Application number: 2026/91869	
What is the application for?:	Change of use of dwelling (Use Class C3) to childrens care home for up to two ch
Address of the site or building:	4, Armytage Crescent, Lockwood, Huddersfield, HD1 3TY
Postcode:

Type of comment: An objection	
Do you wish your comments to be published on the website anonymously?	Yes
Objection to Planning Application 2026/91869 – 4 Armytage Crescent, Lockwood, Huddersfield Change of Use from C3 Dwelling to C2 Children's Care Home I wish to object to the above application on the following material planning grounds: 1. Severe parking congestion and unsafe access (LP22) Armytage Crescent already suffers from significant parking saturation, with most households owning multiple vehicles. On street parking is routinely obstructed, and emergency/waste vehicles already struggle to access the street. A C2 children's home requires 24 hour staffing, shift changes, visiting professionals, and service vehicles. This materially increases parking demand beyond what the street can safely accommodate. The proposal does not meet the requirements of Local Plan Policy LP22, and no parking strategy has been submitted. Kirklees has recently re

Site Plan
Scale 1:200

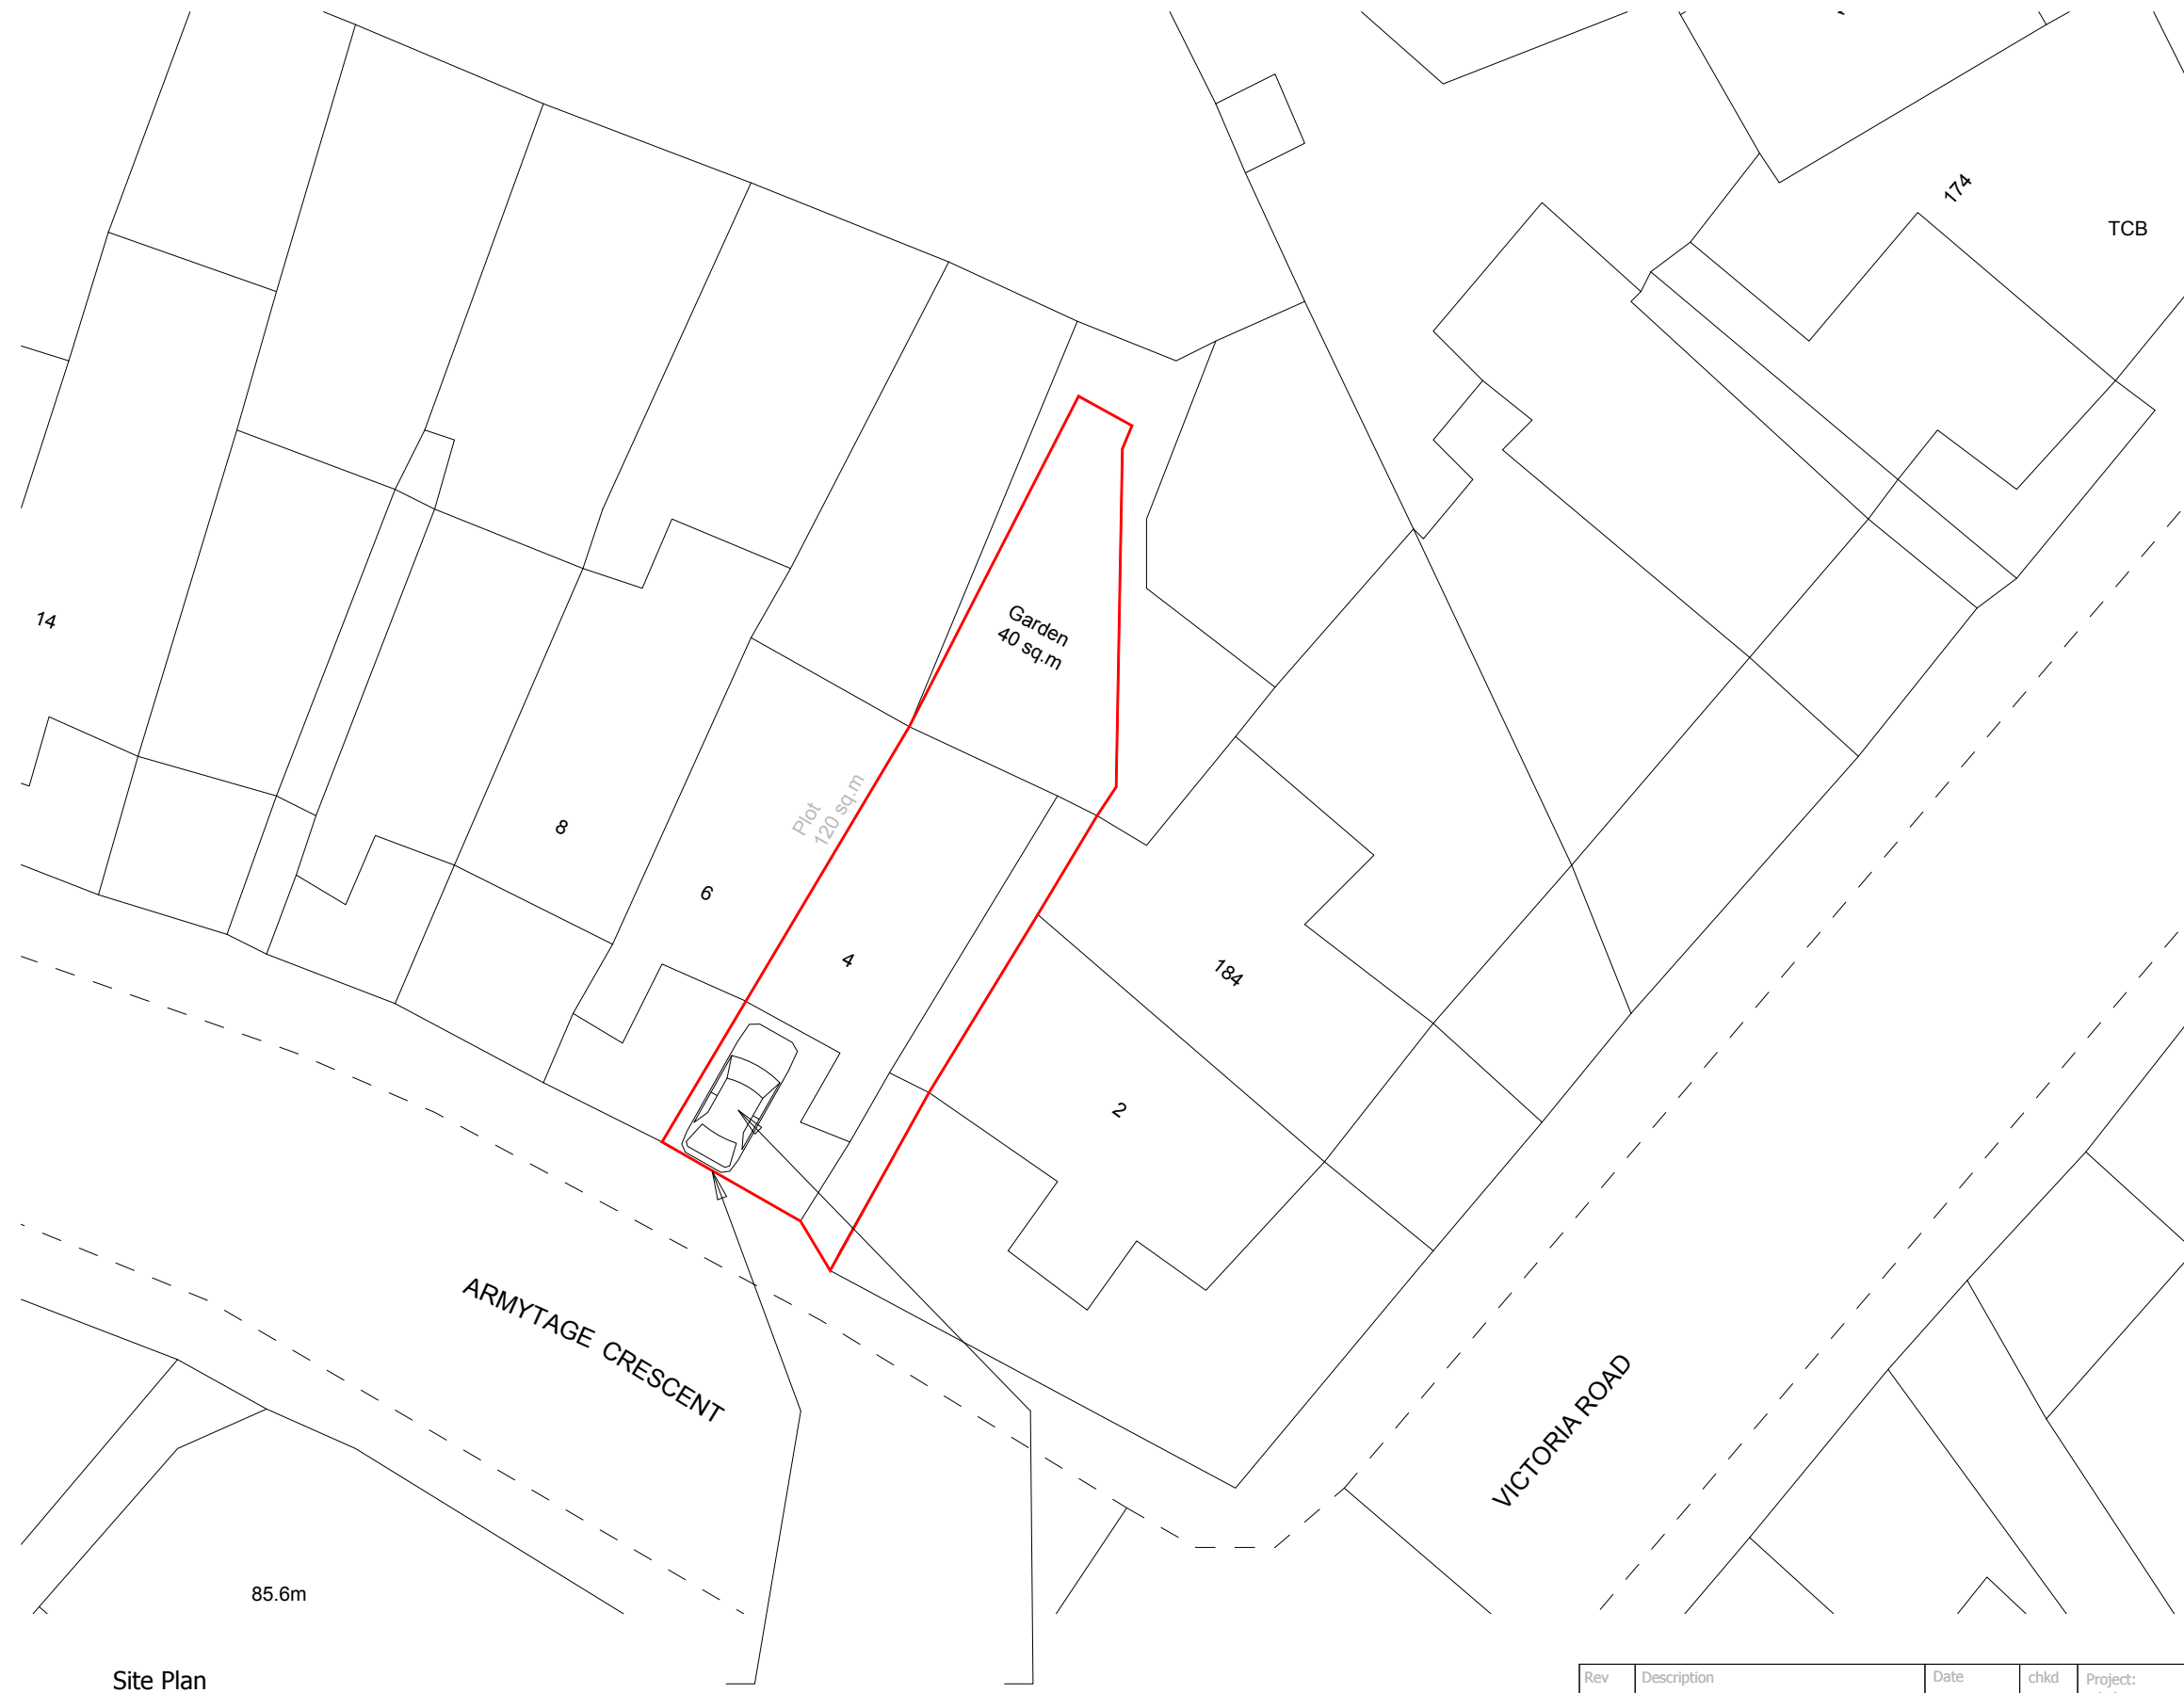
The property and plot size are insufficient to support the operational needs of a C2 home, including staffing, supervision, parking, and outdoor space.
